Our Ref: R/2019/17/A
File No: SSD 10376

Pitt Street South Over Station Development Stage 2 – SSD 10376

Thank you for your correspondence dated 4 June 2020 seeking comment on the detailed design of the Pitt St South OSD. The following comments are provided by the City of Sydney (the City) for your consideration:

Figure 2-1: South OSD access locations on the ground floor (drawing no: SMCSWSPS-BAT-PSS-AT-DWG-910041)

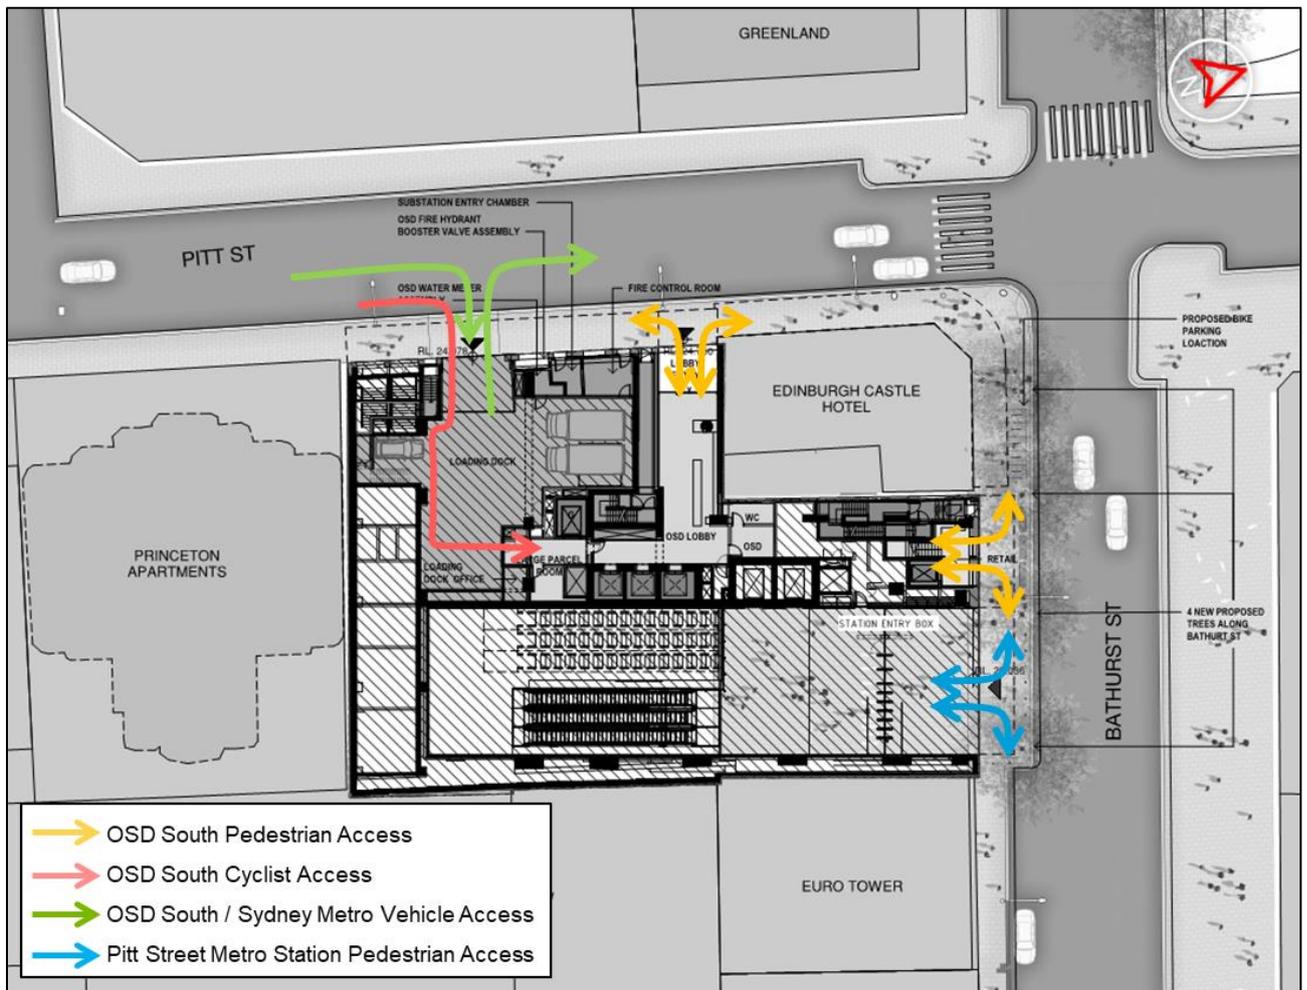
- a) The site proposes residential uses and must accommodate a Council waste truck. However, the height restriction of the proposed driveway is 2.6m which prohibits council collection. The City requires clearance height for access by collection vehicle to be no less than 4m at any point if the vehicle is required to enter site to service bins.

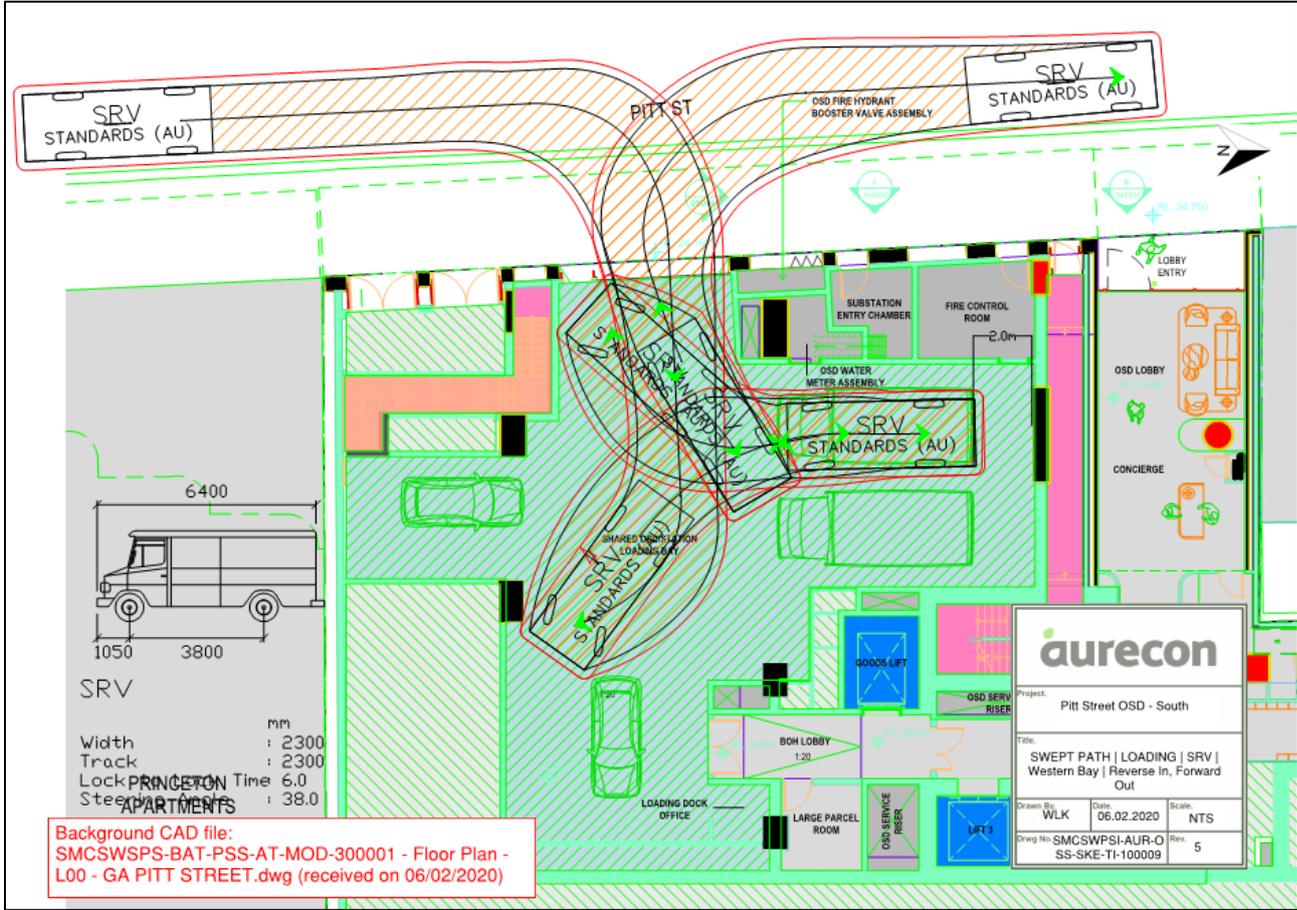
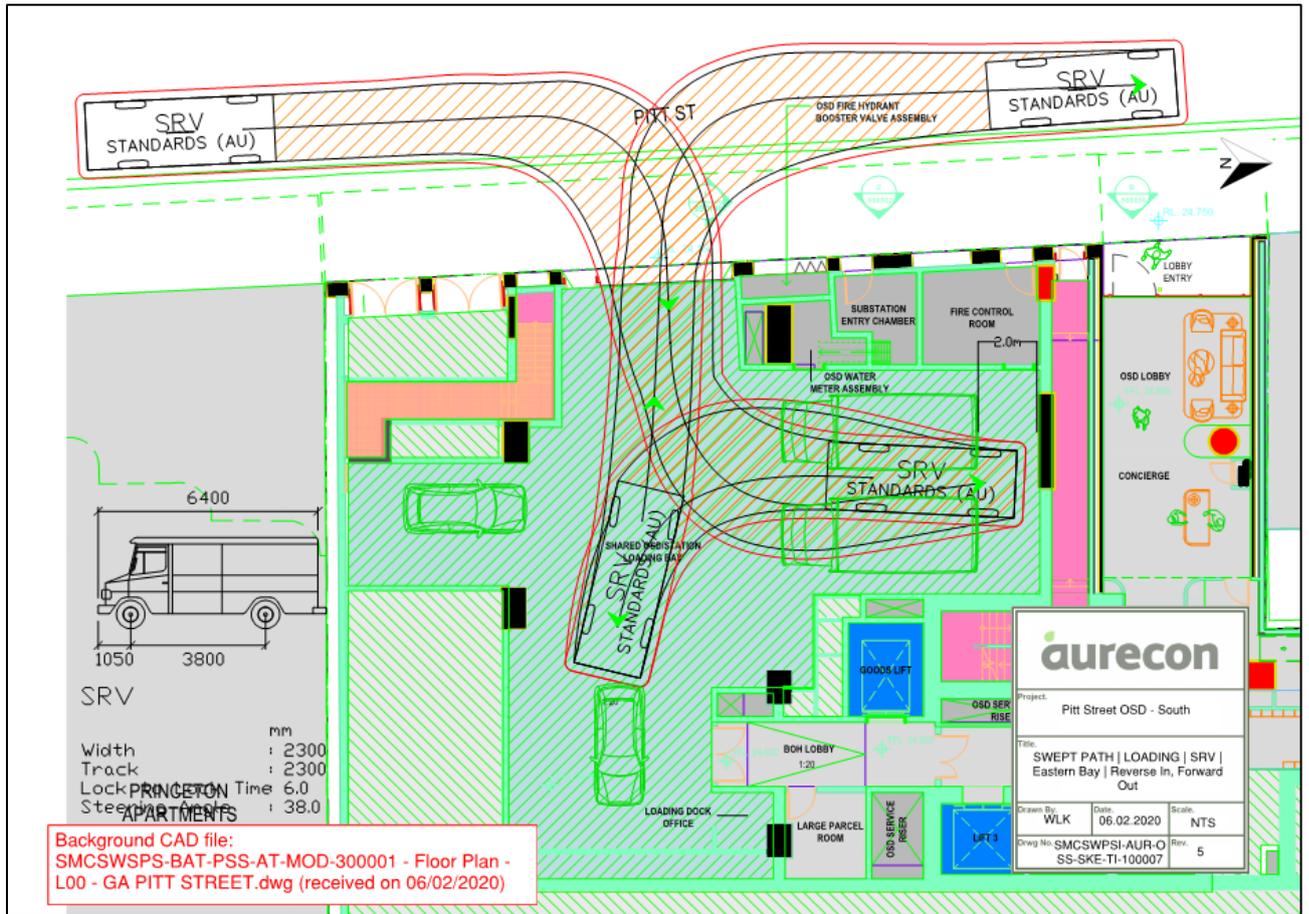
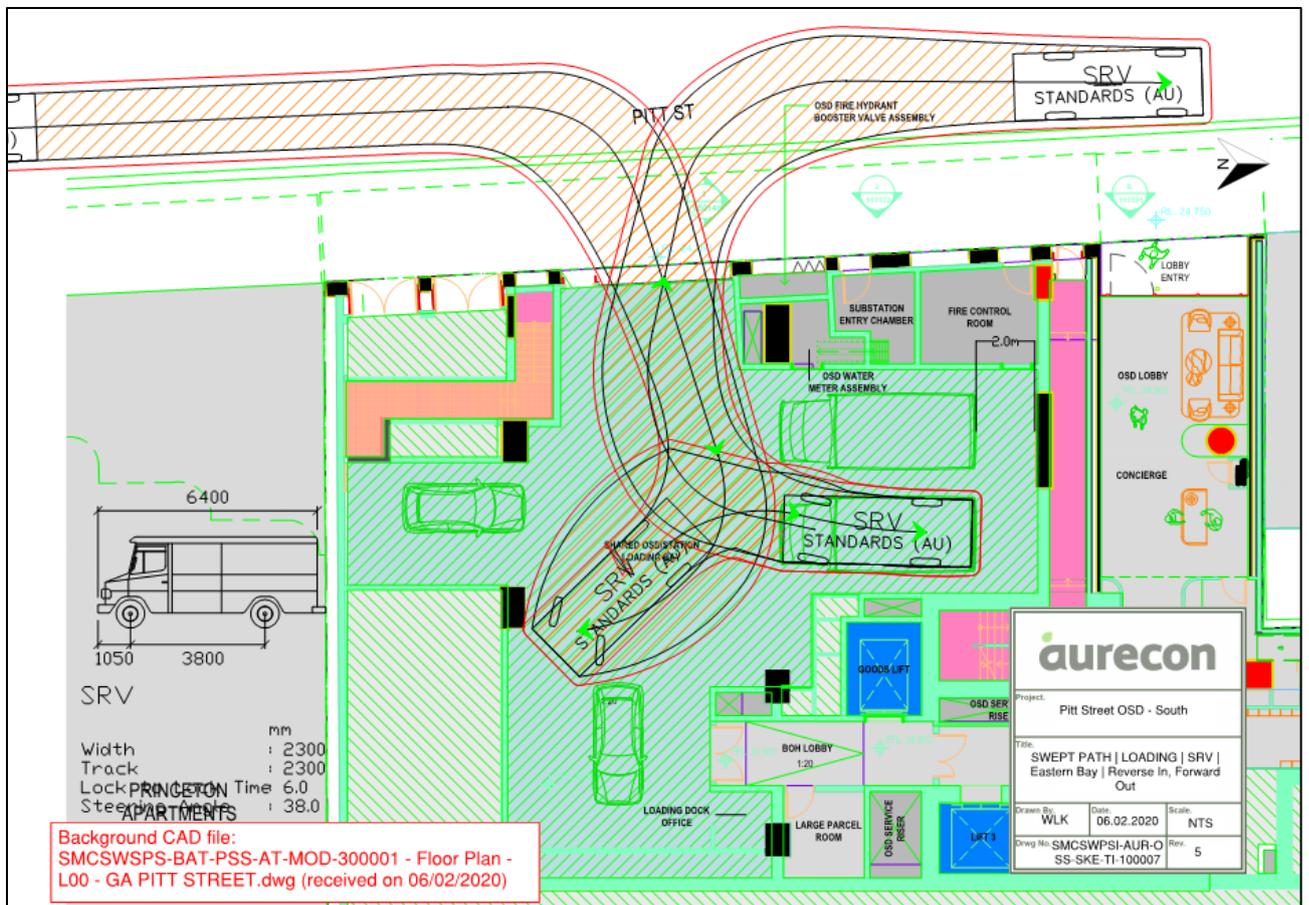
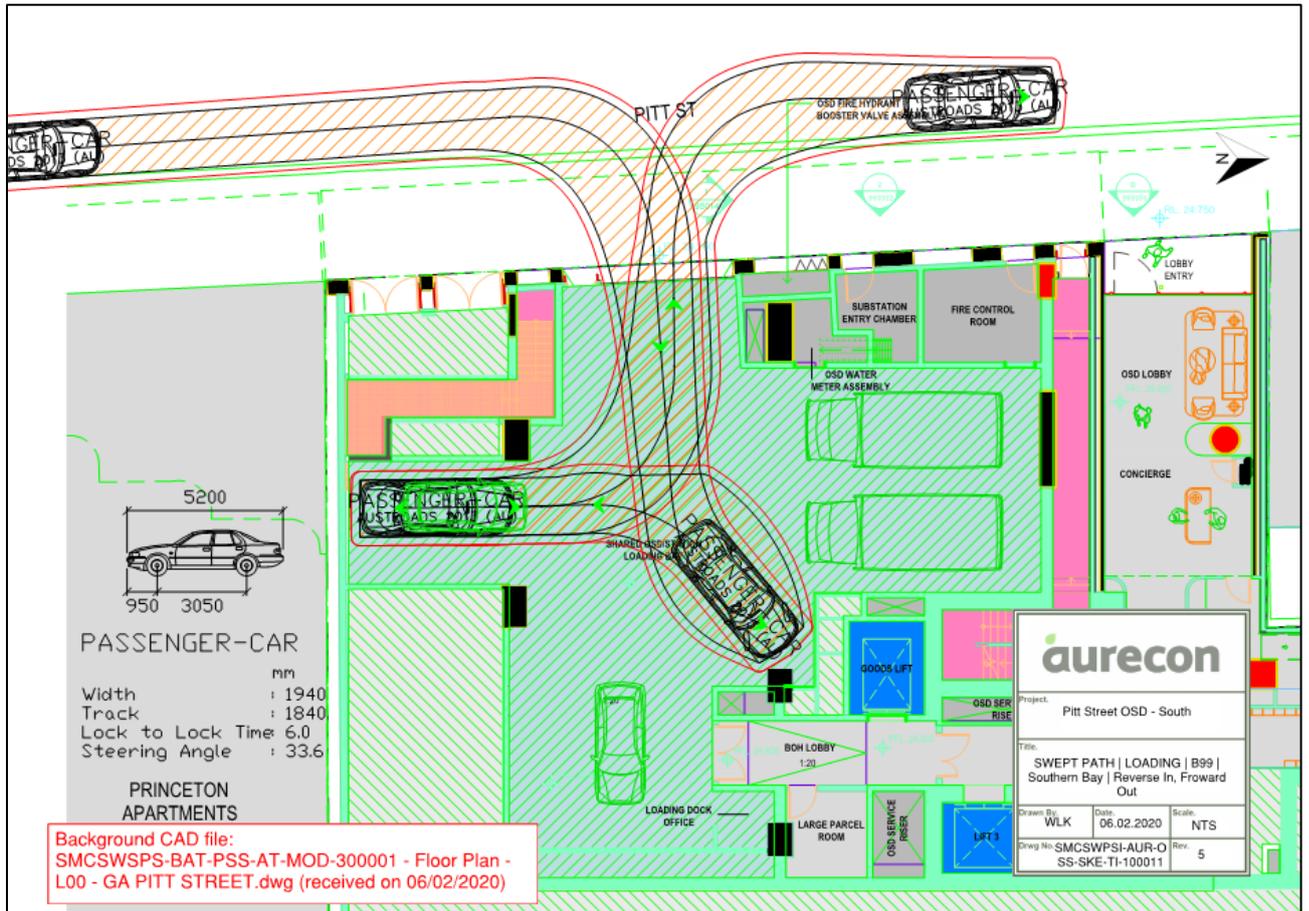
- i. One loading bay is for exclusive use of Metro;
 - ii. The Swept Path Analysis does not demonstrate clearly the ability for the site to accommodate two SRVs simultaneously – particularly if a garbage truck is using the site – then only one other bay is accessible.
